27 November 2019

M12 Motorway (SSI-9364)

SSI – 9364 M12 Motorway Penrith City Council Submission

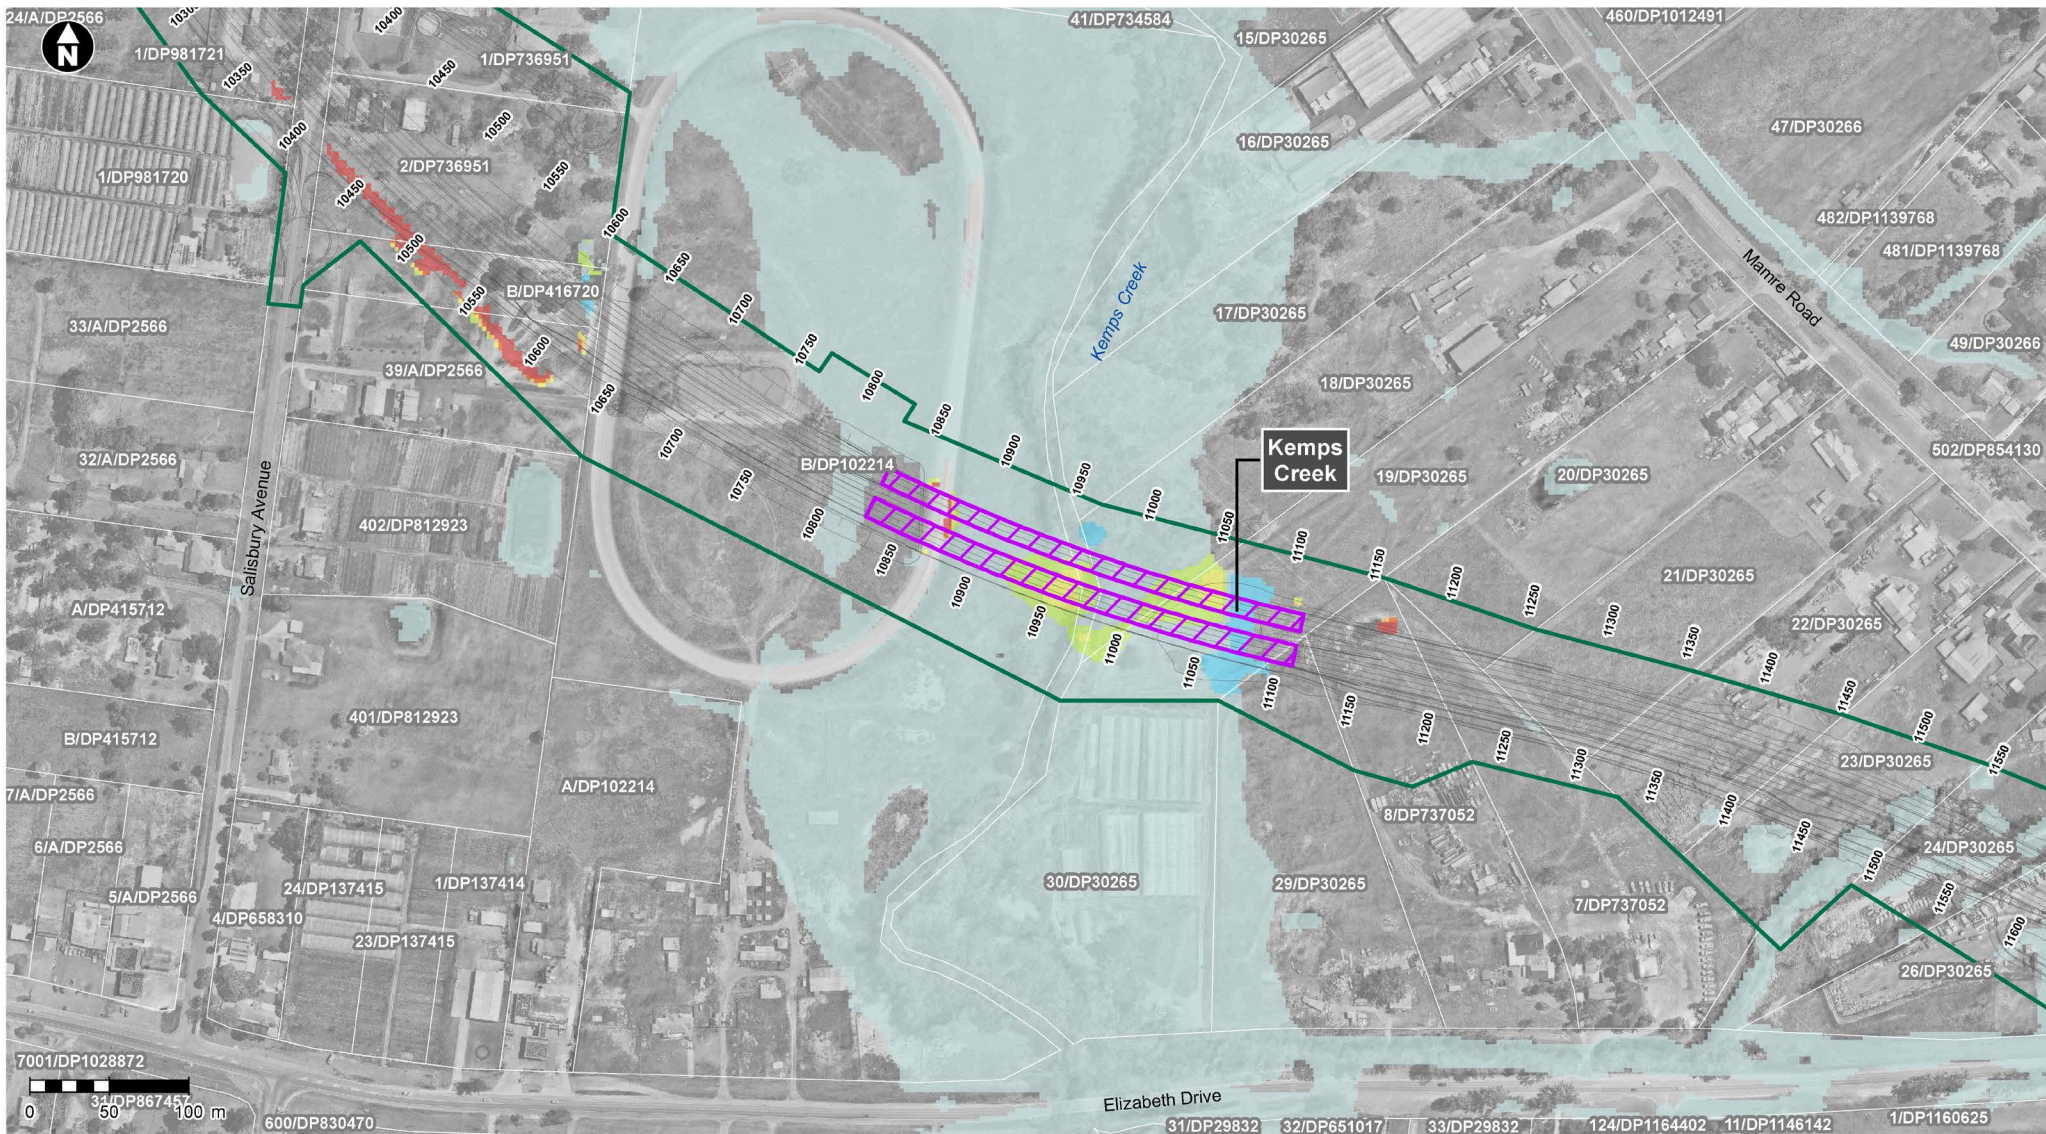
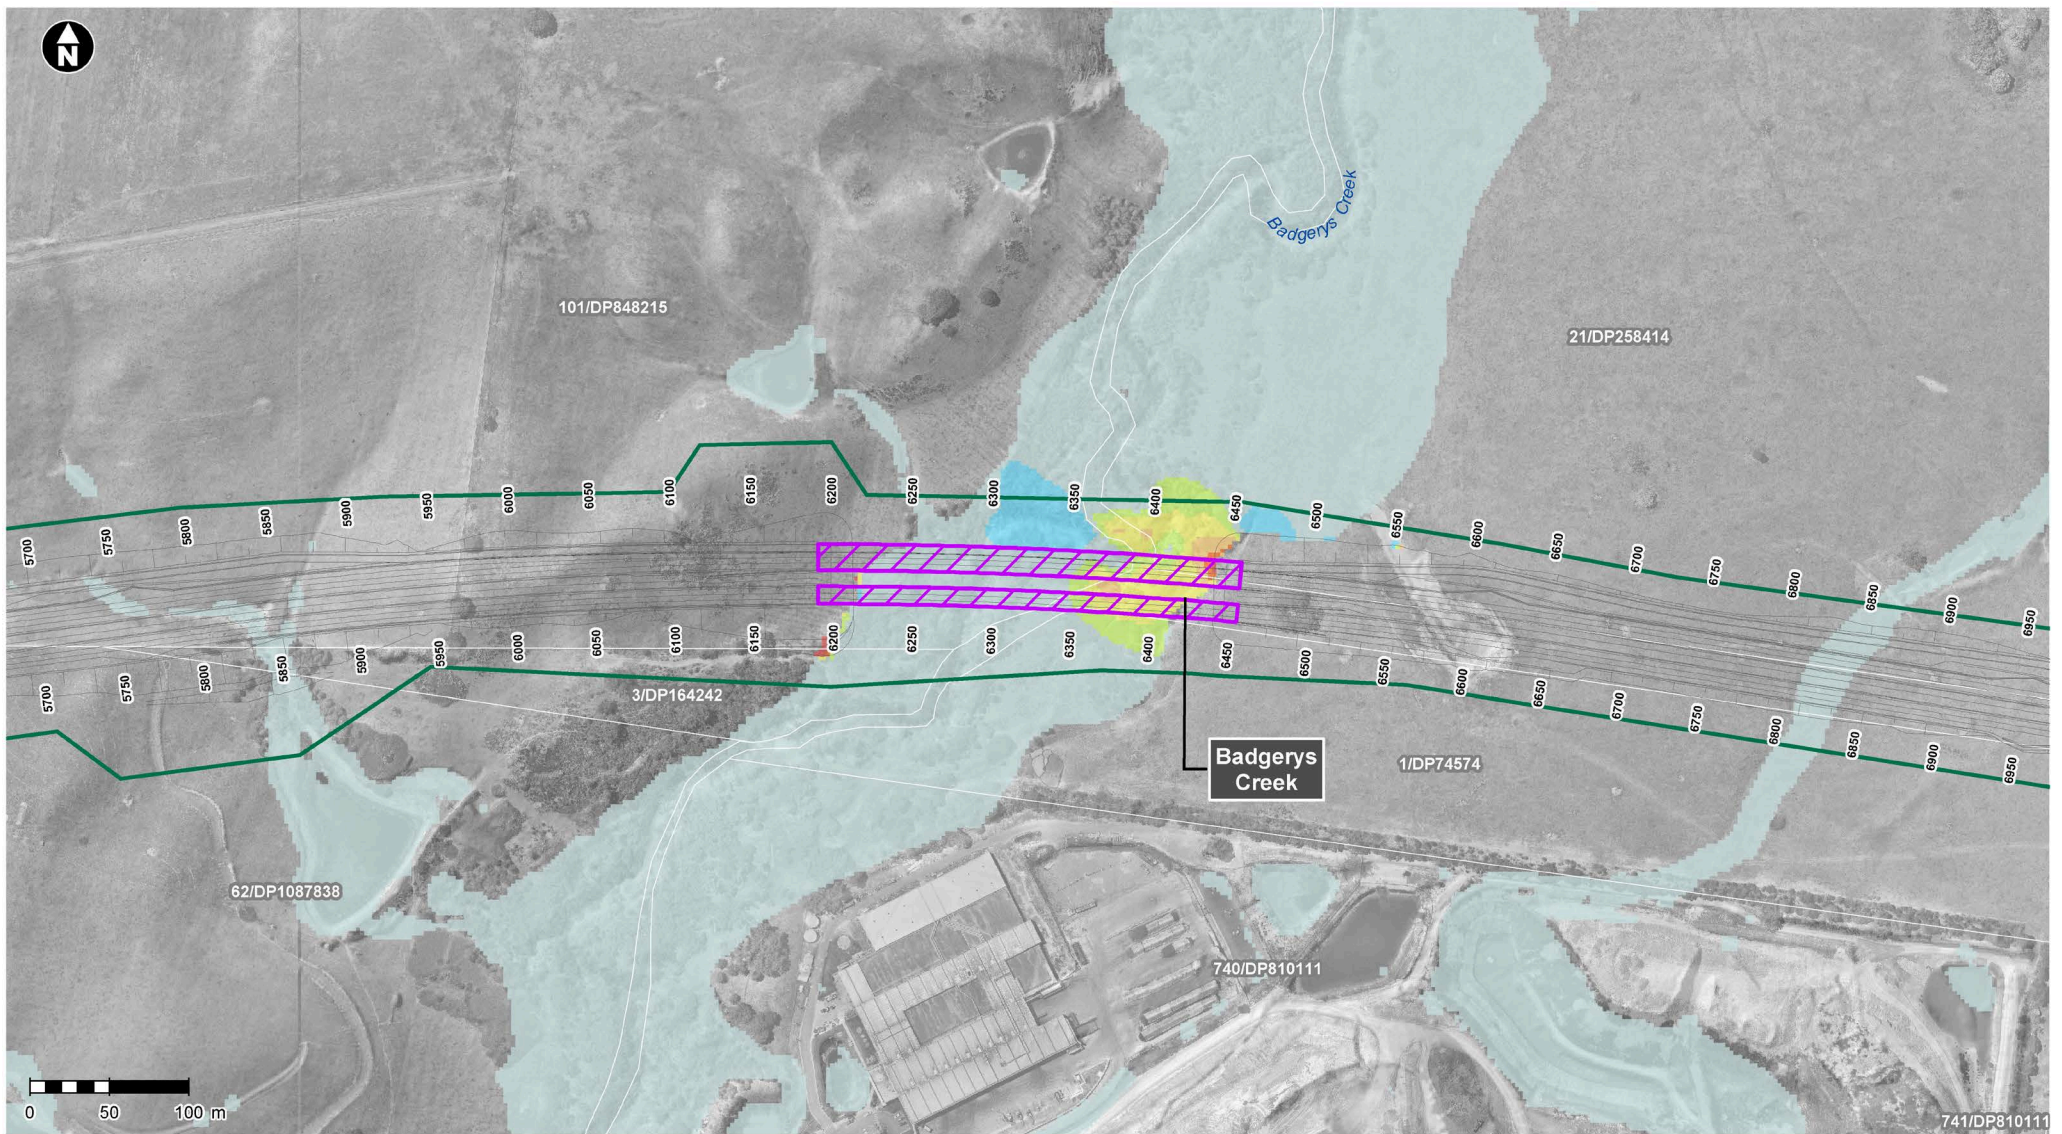
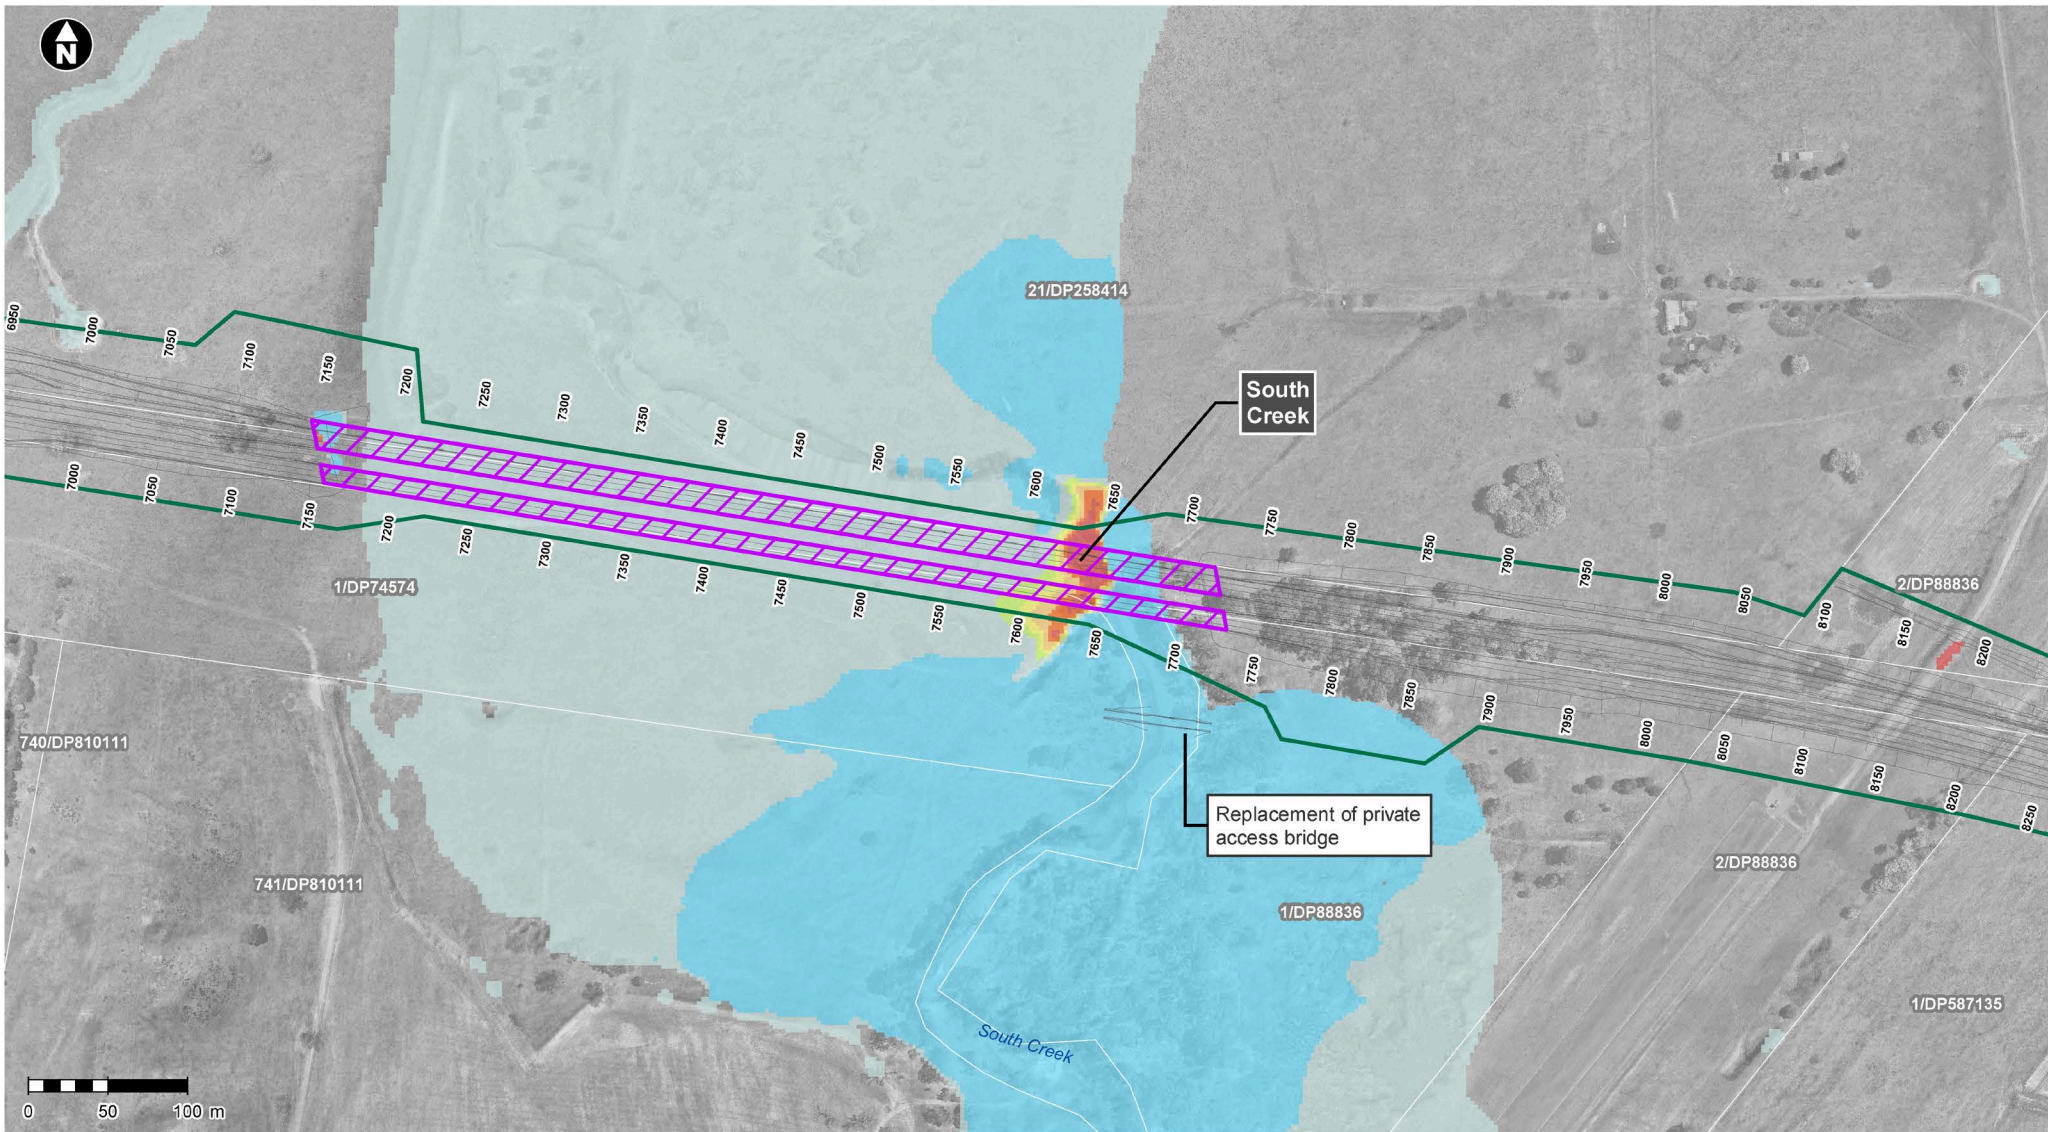
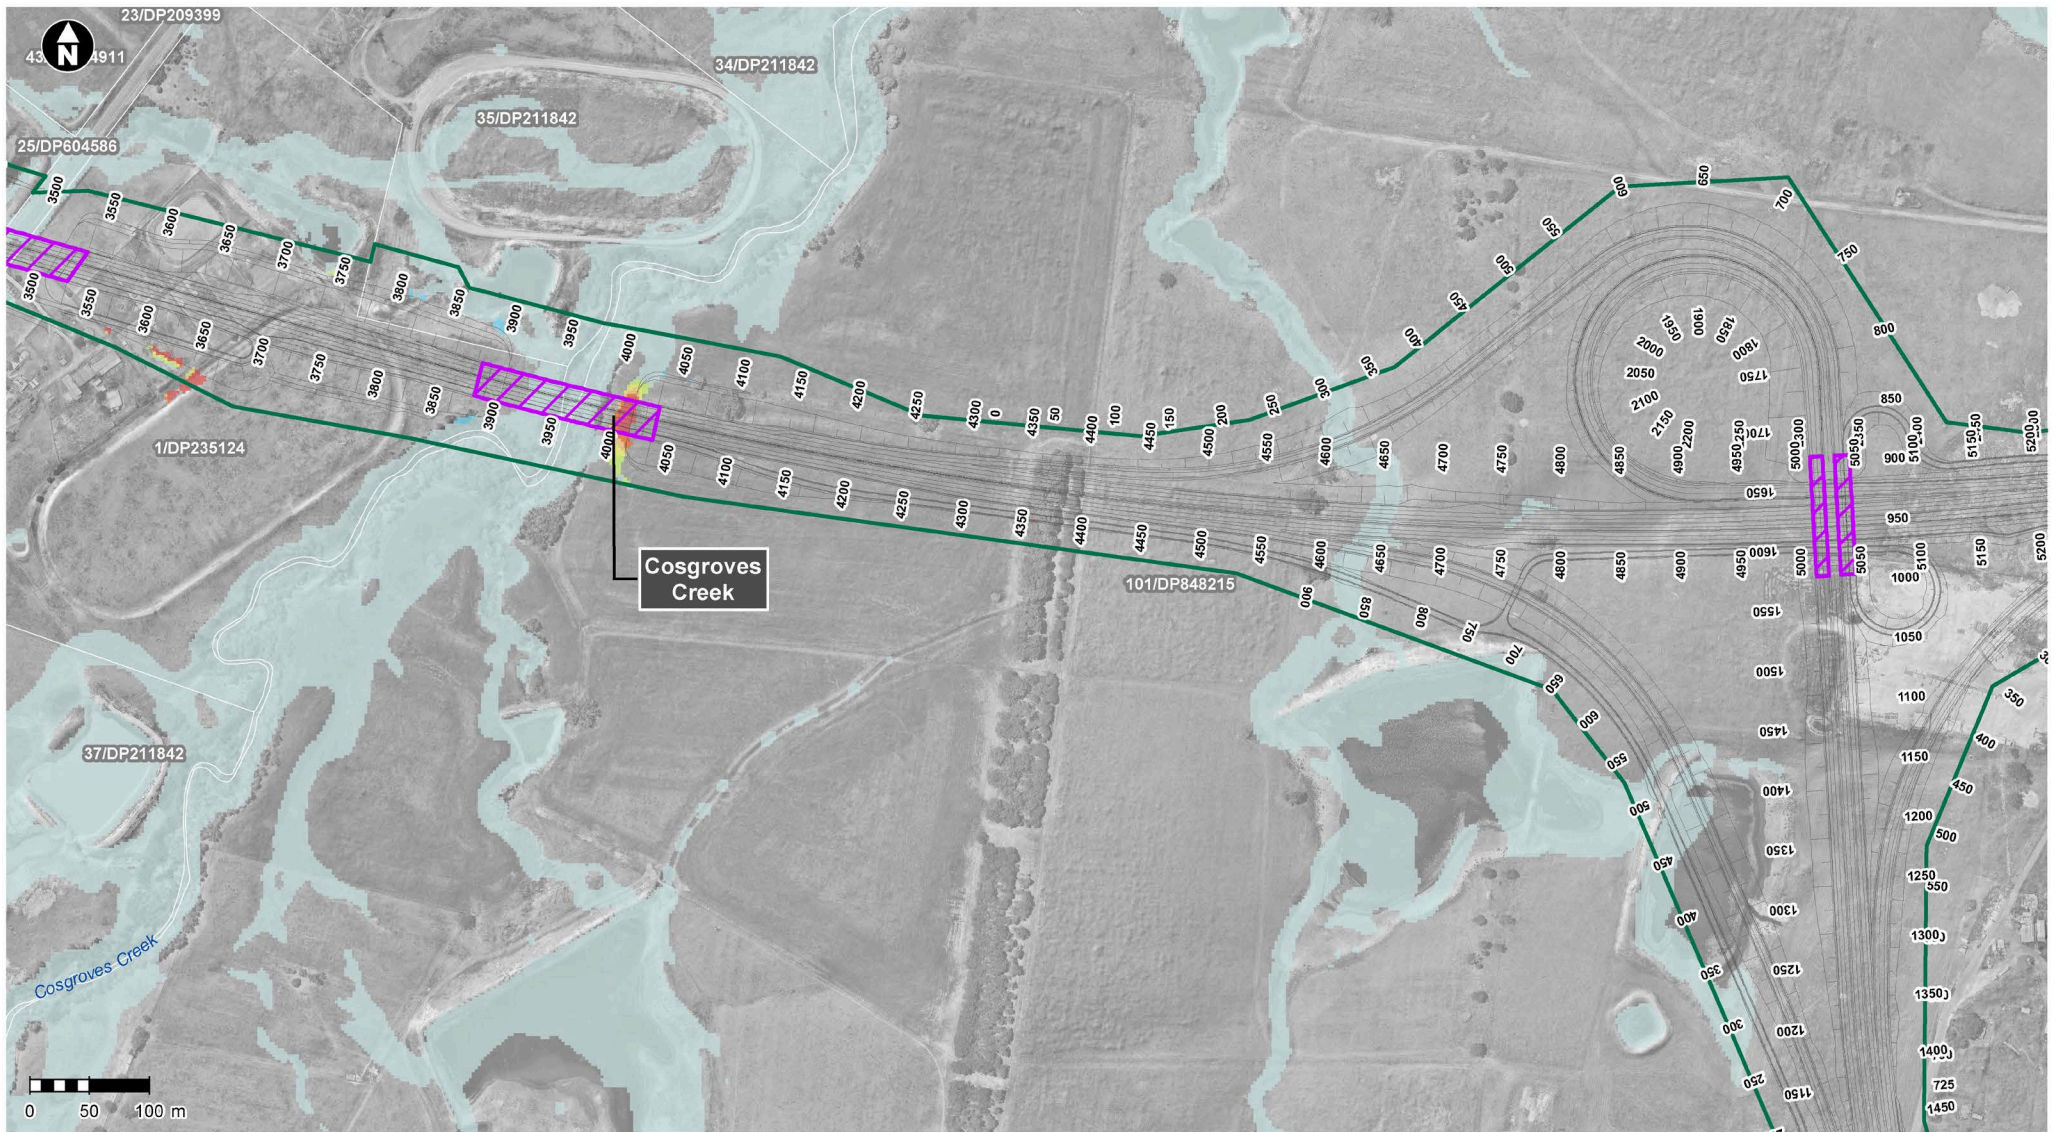
- The EIS identifies that the bridges will span across the 1:100 year flood extent. However, some plans and diagrams illustrate the bridge span falling short of the illustrated flood areas. It should be confirmed that the plans to be relied upon for the bridge extent align with the mitigation measures outlined within the EIS being an expanse for the full width of the flood zone;
